From: Ian Gledhill [REDACTED]
Sent: 14 May 2014 09:18
To: Neil Crowther
Subject: WSCC Highways - Additional Response LU/51/14 - Land south of Littlehampton Academy
Attachments: LU5114 - Land South of Littlehampton Academy; RE LU5114 - Land South of Littlehampton Academy

Neil, I've now received additional information from the Applicants regarding the above. I have responded directly to this information and this overcomes the issues raised within my initial planning response. There would be no highway objection to this proposal. I have attached both my response and the information from the Applicant.

Client			
West Sussex County Council			
Project			
Land South of Littlehampton Academy			
Drawing Title			
Proposed Eastern Access Arrangement			
Scale	Drawn By	Checked By	Approved By
1:250	PJB	PJC	PMR
Drawing No.	Date	Rev.	
13/1693/002	September 2013	A

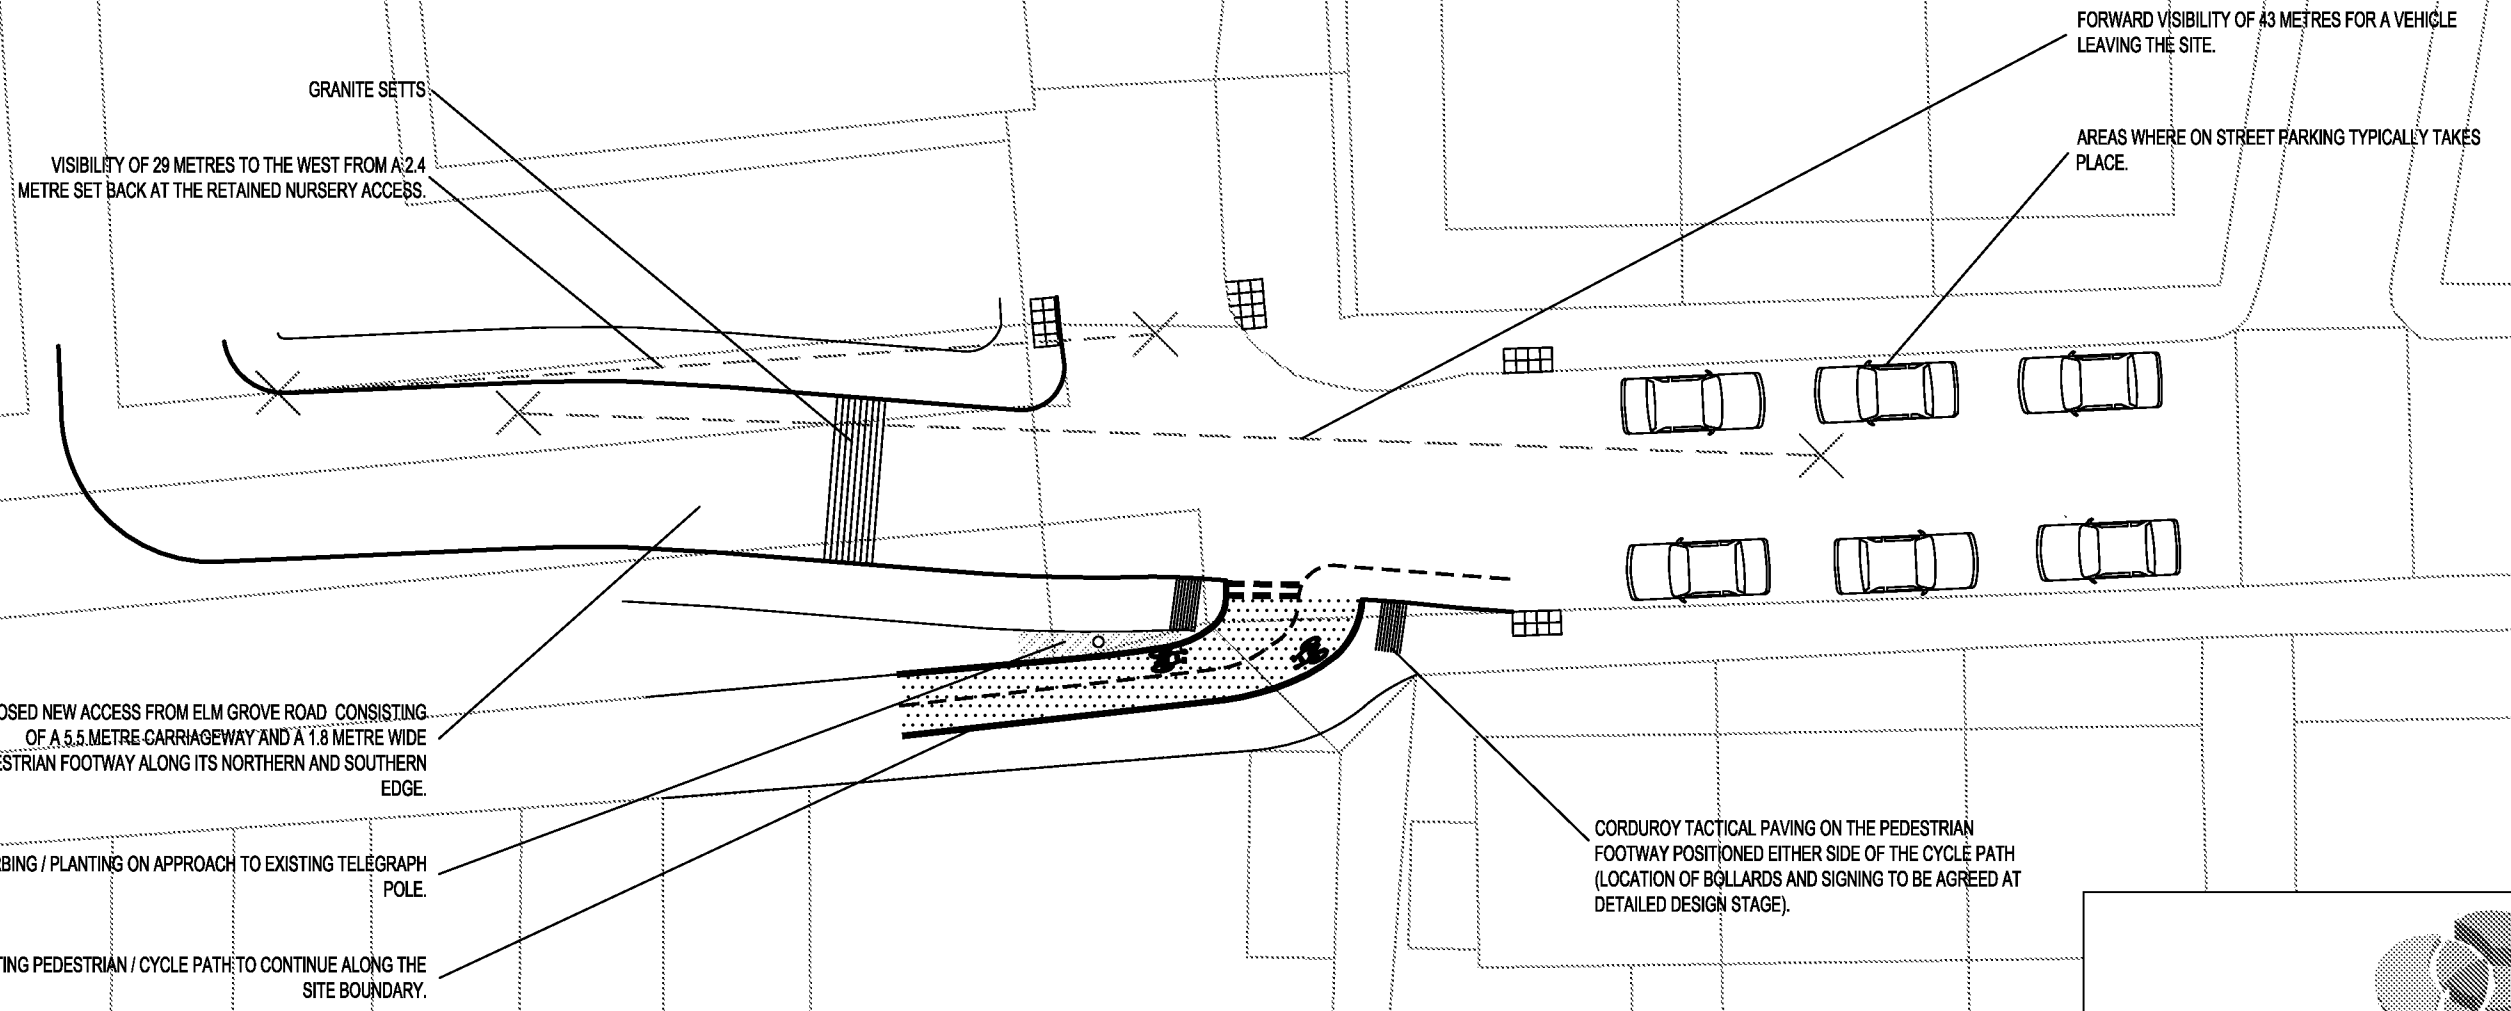
No dwelling served from Elm Grove shall be first occupied until such time as the existing access, footways and cycle path onto Elm Grove have been constructed in accordance with the details indicatively shown on drawing number 13/1693/002 Revision A.
